Subject: Review Comment Response
Geologic Hazards Evaluation
Preliminary Geotechnical Investigation
Crossroads North
Marksheffel Road and State Highway 24
El Paso County, Colorado
Project No. CS18526.001-105

This report letter presents our response to the Colorado Geological Survey (CGS) review comments regarding our Preliminary Geotechnical Investigation. The following discussion provides specific items from the CGS comments and our responses.

CROSSROADS NORTH PRELIMINARY GRADING PLAN

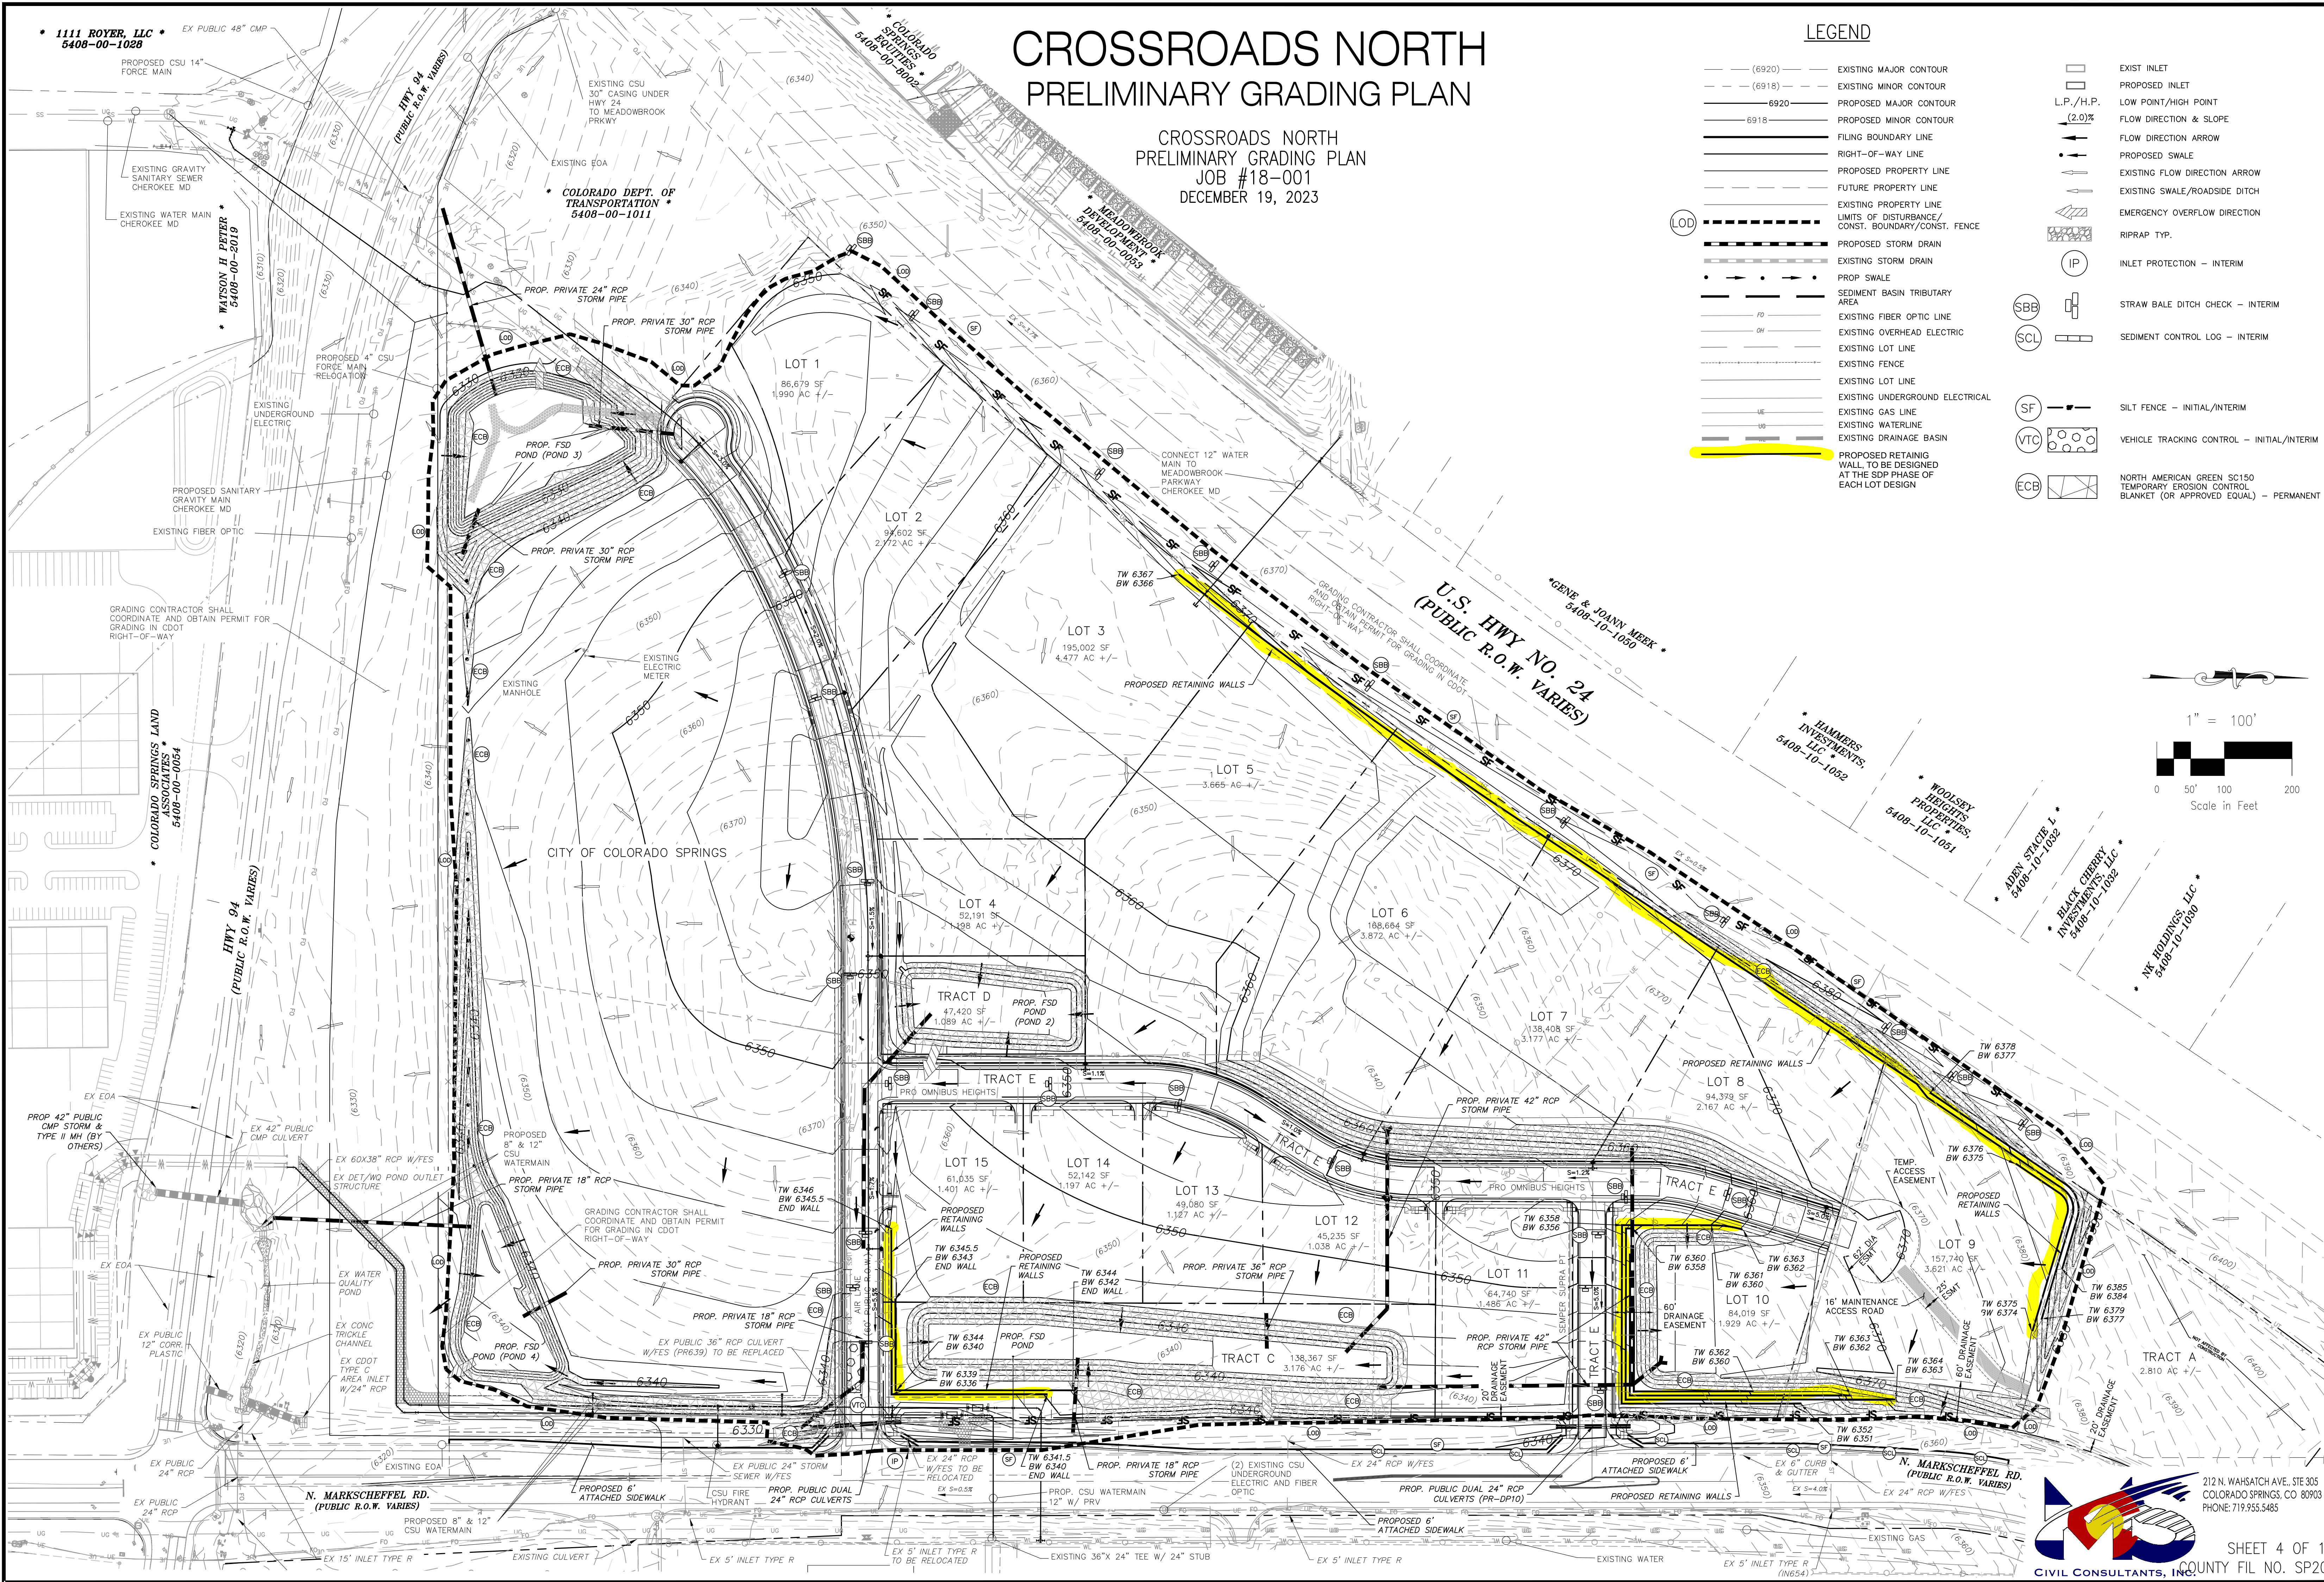
“CGS received grading plans with this submittal, while CTL|Thompson indicated they did not review such plans. CGS recommends that the county or developer provide CTL|Thompson with grading plans, and they review the plans for conformance with the geotechnical report recommendations. The geotechnical report states that eolian soils underlie the site. Once wetted and loaded, such soils can settle and cause damages to buildings, pavements, and other infrastructure. CTL|Thompson indicates that the risks to proposed structures form hydrocompactive soils are low for lightly to moderately load structures (one to two-story buildings). The report contains limited soil testing to determine the risk or degree of the potential of hydrocompaction.”

We have received the preliminary grading plans from Kimley-Horn. As the CGS notes, the sands that underlie the site have the potential to be hydro-compactive. Based on the testing data available on the site the soils classify as having low to moderate collapse potential using the criteria from CGS publication EG-14 “Collapsible Soils in Colorado,” Fig. 4-13. The soils with the higher potentials are generally spread across the site. Limited testing was preformed because the lack of fines and low moisture contents in the natural sands precluded

most of the samples from being suitable for swell/consolidation testing, due to a lack of structure in the soil matrix.

We provided a brief discussion of possible mitigation options in our report. Based on the preliminary grading plans portions of the site will have significant amounts of fill in excess of 15-feet. Deep fill could help mitigate potential differential movements if settlement of natural soils were to occur below the fill. The possible presence of potentially hydro-compactive soils should be further addressed at the time of the design level reports. We did not find any contradictory conditions based on our review of the preliminary grading plans, and hold that the findings of the Preliminary Geotechnical Investigation and Geologic Hazard Evaluation remain valid for the site.
